In response to the Notice of Exhibition for Walsh Bay Arts & Cultural Precinct (SSD 8671), Walsh Bay, FRNSW notes comments provided by ARUP as part of the report titled "Infrastructure NSW, Walsh Bay Arts and Cultural Precinct, Fire Engineering Phase 1 Concept Review Rev D dated 12 September 2017" and recommend the following conditions be imposed:

Daire Fleming

Fire Safety Advisory Unit

Figure 16 Plan showing location of the existing fire hydrant boosters serving Wharf 4/5 and 2/3

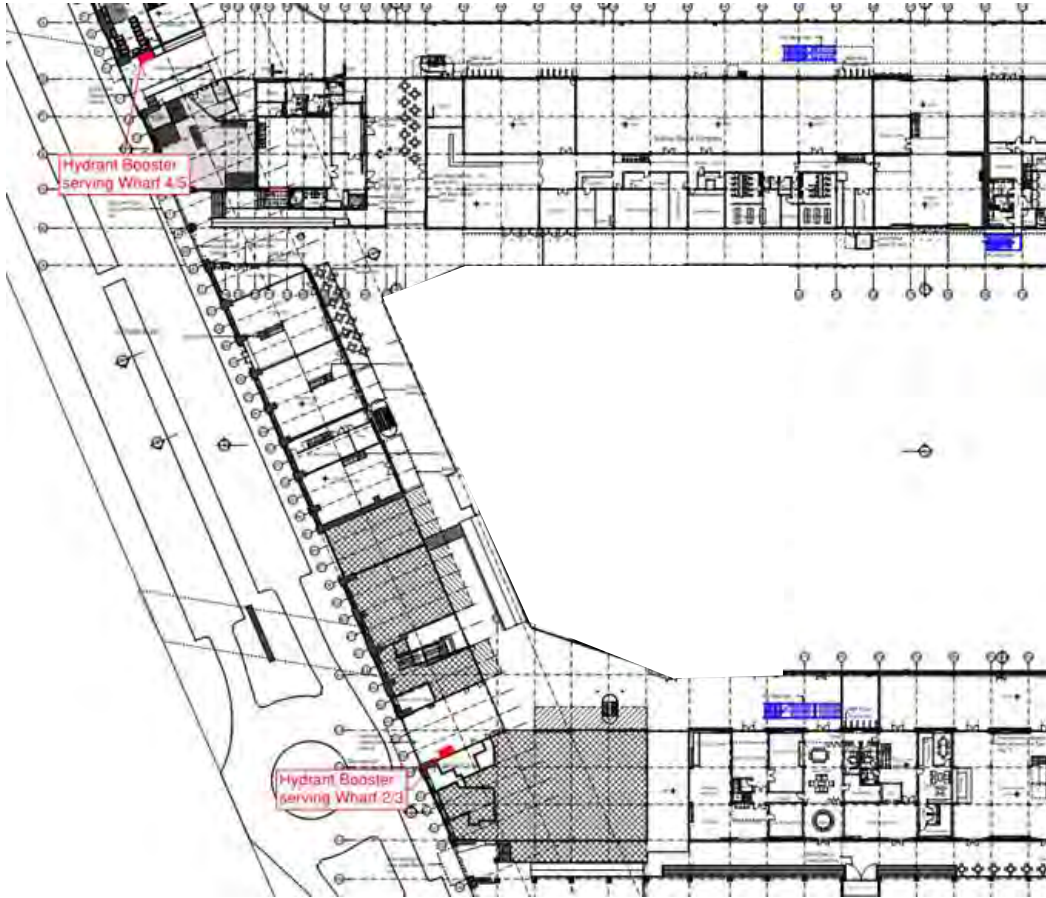
1. FRNSW recommend that the booster location/s be provided and **approved** to the satisfaction of FRNSW (as the authority required to use the system in the event of an emergency).
